Department of Transportation

Traffic & Safety – Permits Unit

August 11, 2026

RE: Kang RV & Contractor Storage (PPR2620)

HORZ. SCALE: 1"=60'	DRAWN: PV
VERT. SCALE: N/A	DESIGNED: JPS
SURVEYED: RIDGELINE	CHECKED: JPS
CREATED: 03/12/26	LAST MODIFIED: 06/22/26
PROJECT NO: 022601	MODIFIED BY: PV
SHEET:	EX1

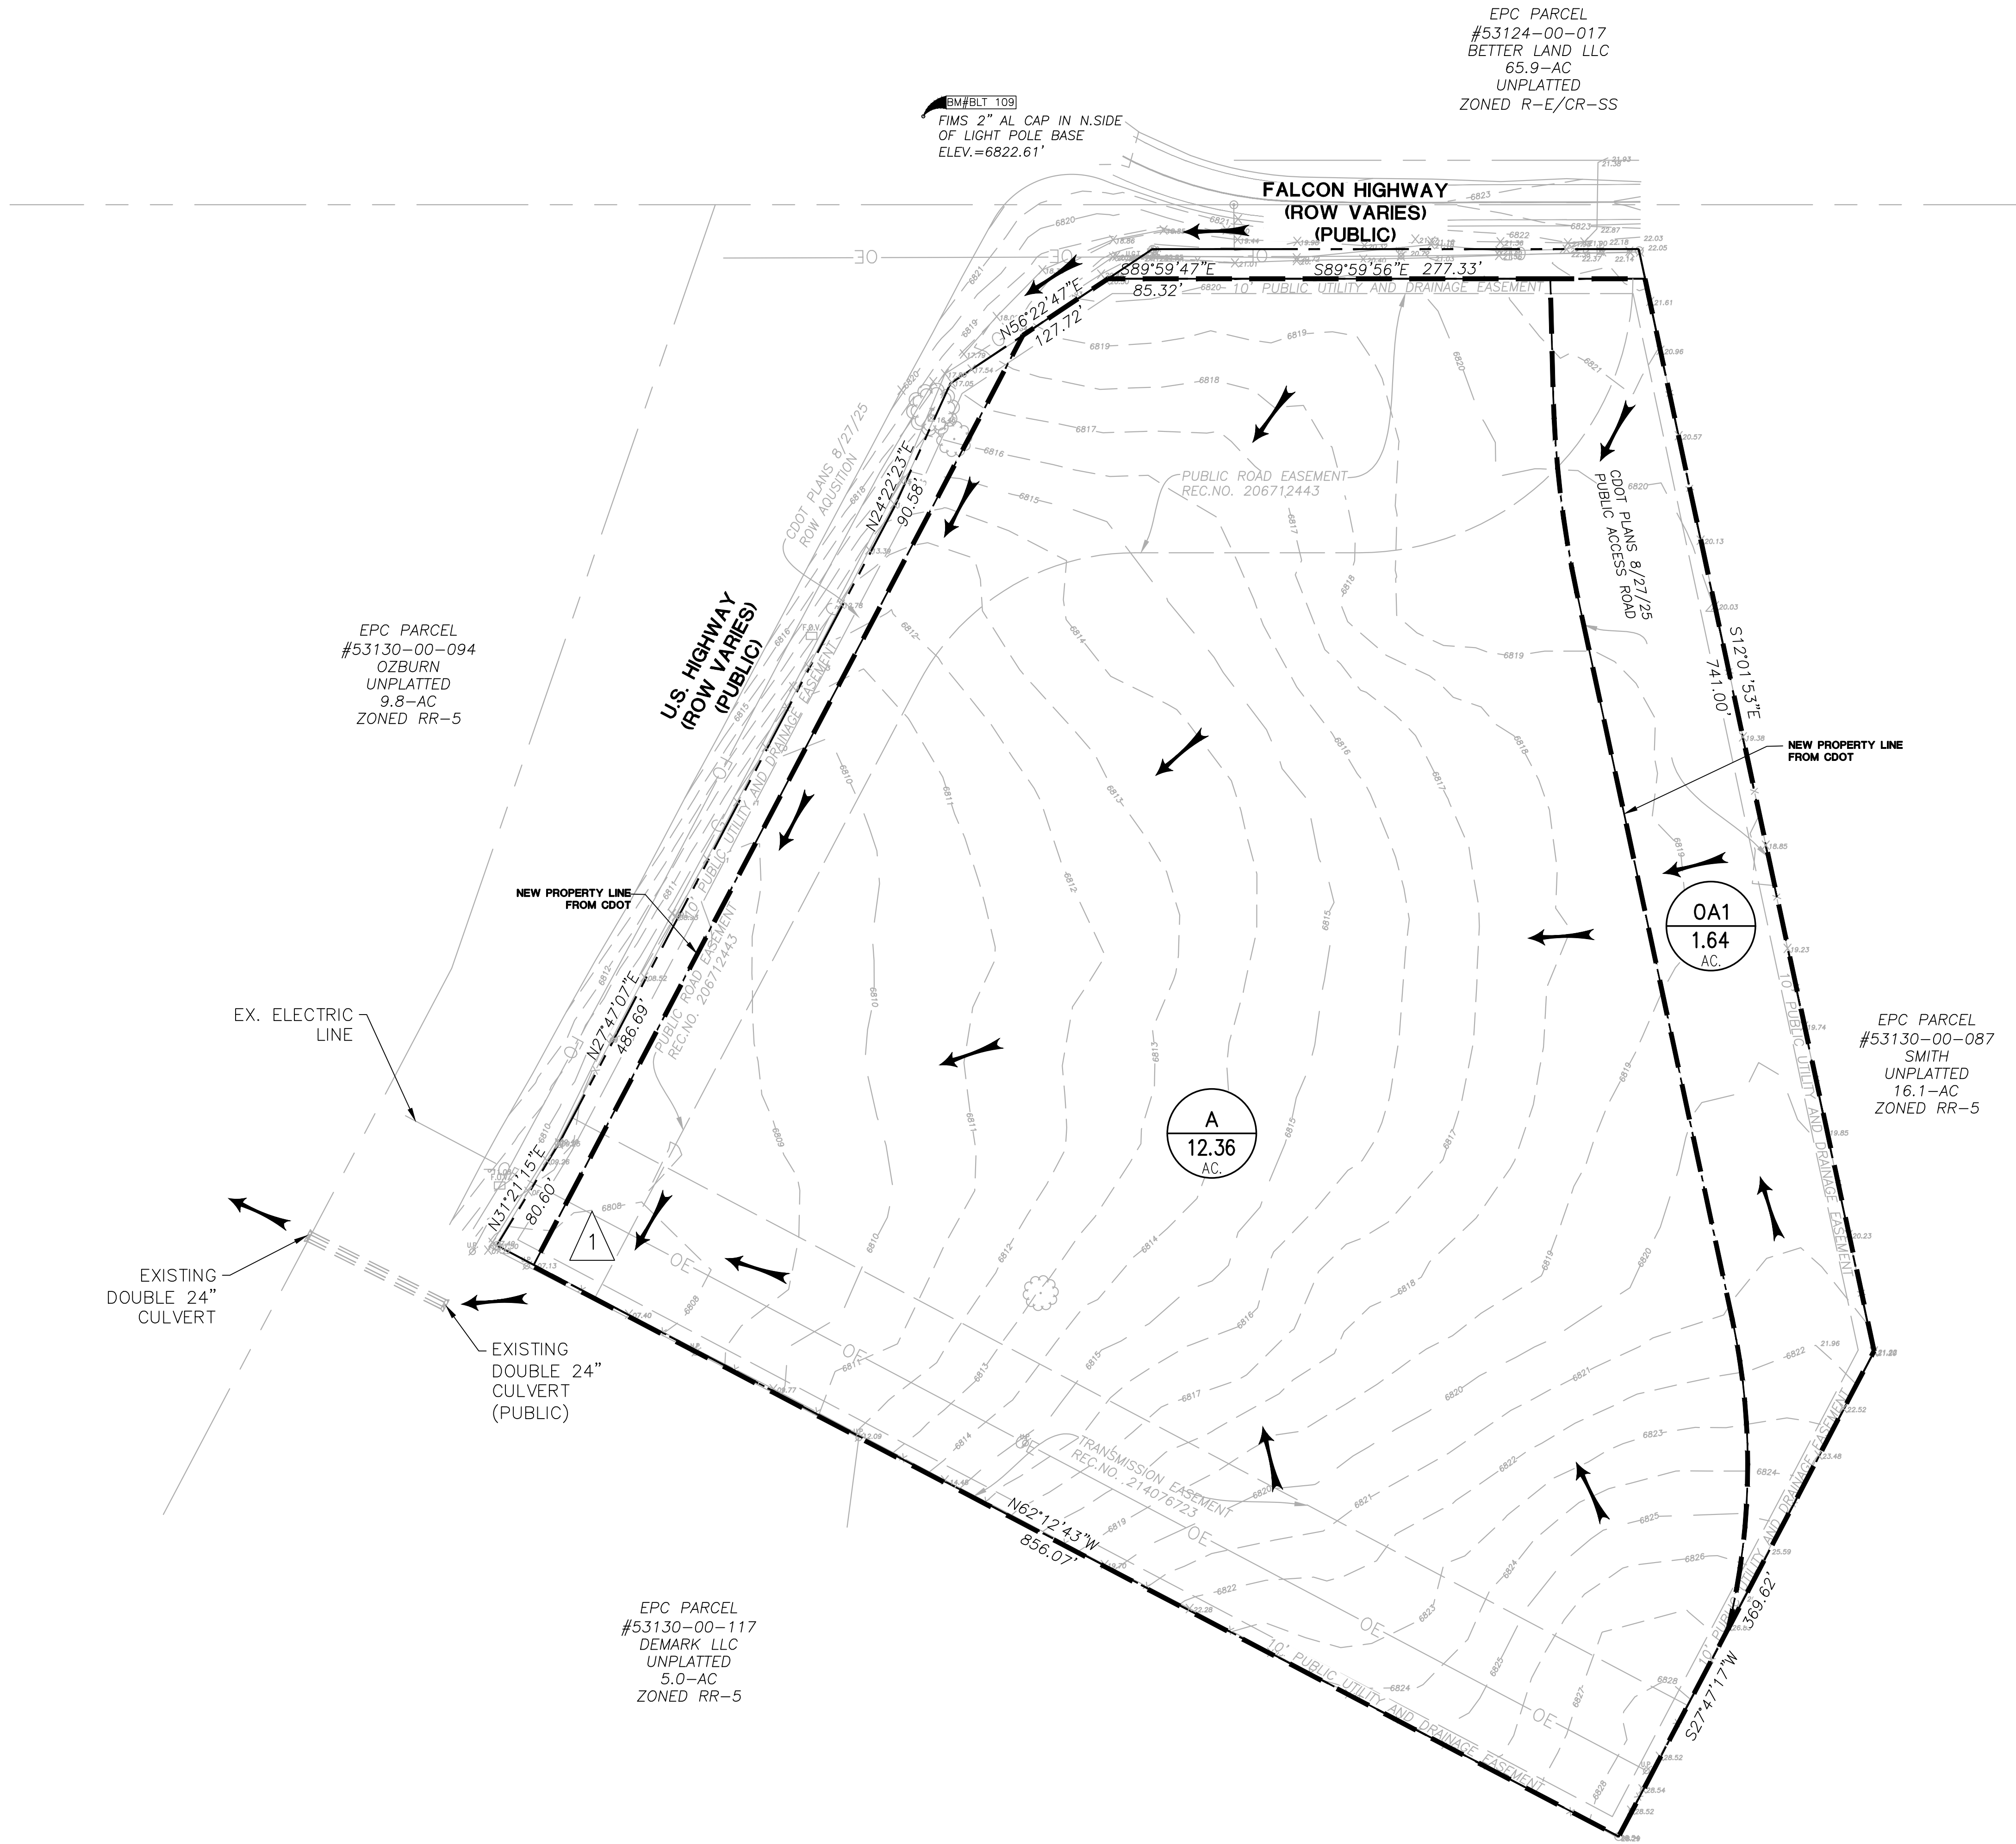
- PDF p 52 – The emergency overflow is identified as discharging to the existing drainage ditch that ultimately ends up adjacent to US024G. Verify there is available capacity to contain the spillway flow without encroaching on the highway. Include analysis of the dual culverts under US24 as well.
